Martin Nugent
01254 828060
D3/11/0605

Drafted 26 September 2011

**Planning Application, Ribble Valley District
3/11/0605 21 Clitheroe Road, Whalley**

Drawing: Proposed Block / Site Plan

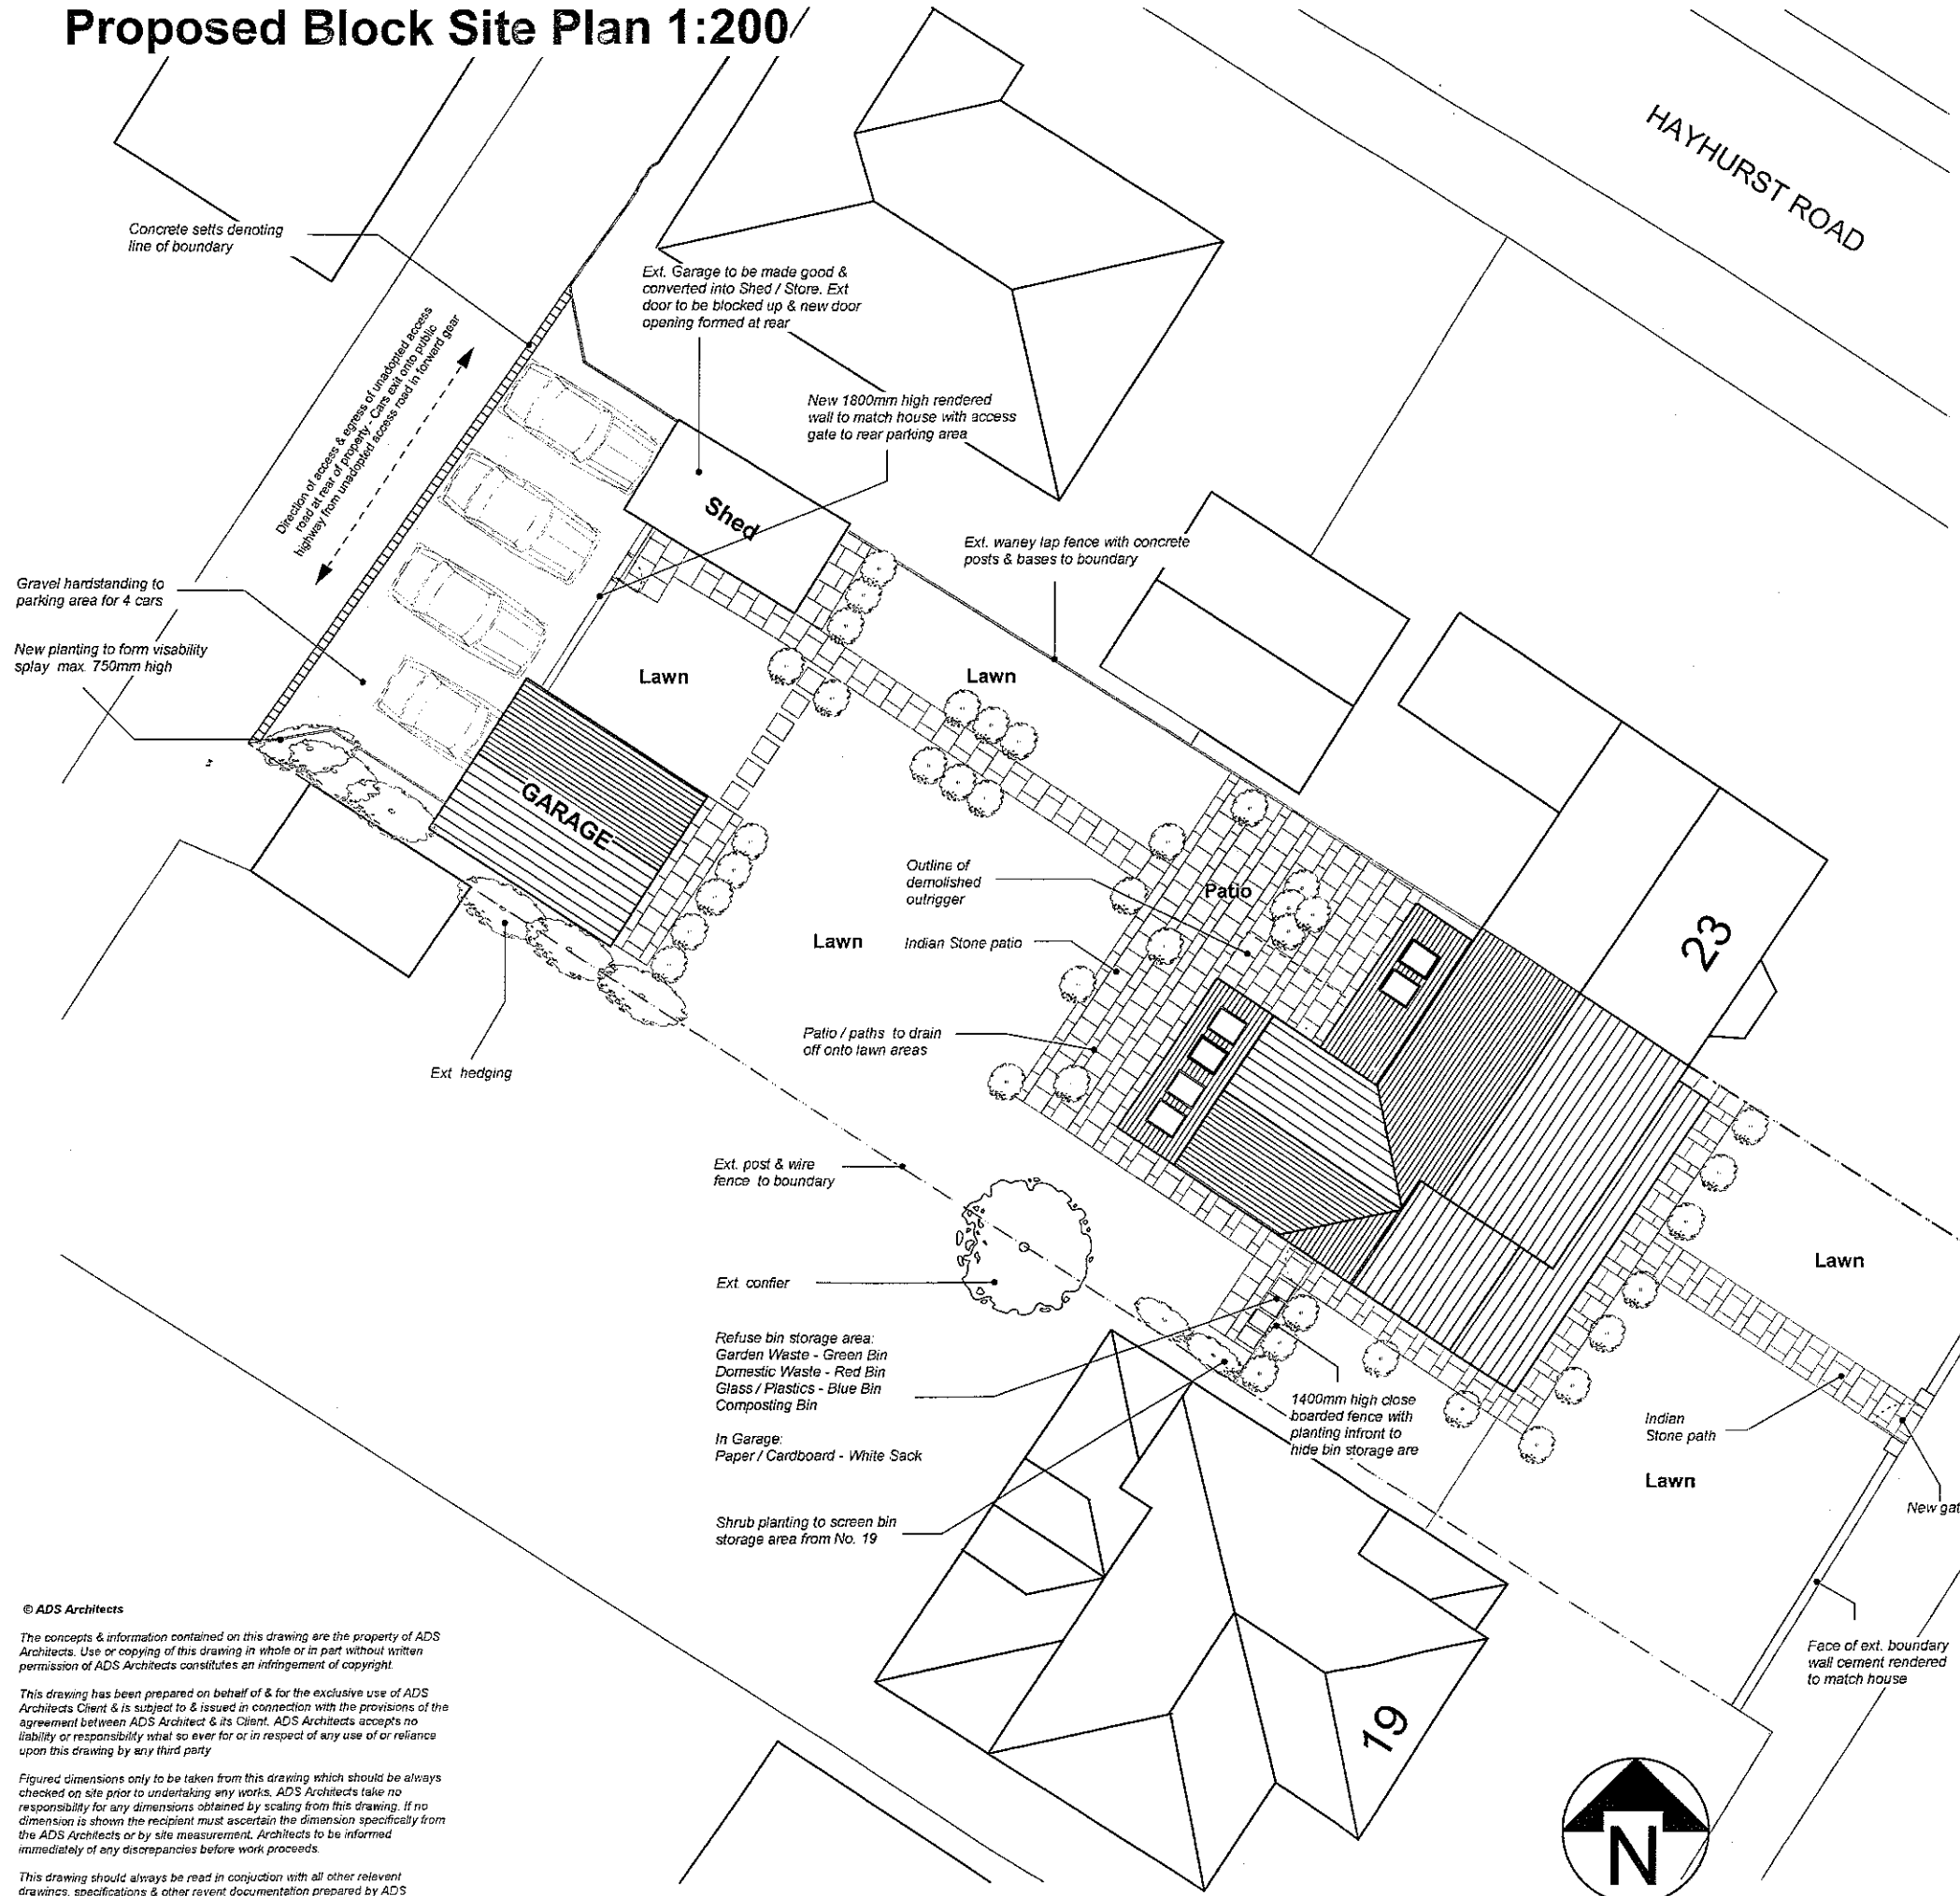
The residential layout provides for a total of four off road parking spaces, including one contained within a detached garage, is the appropriate level of provision for this site. One of the off street spaces shown to the rear of the existing garage (to be converted to a shed as part of the new application) is not included as a defined off road space, being less than 5.0m in depth from the back of the access road.
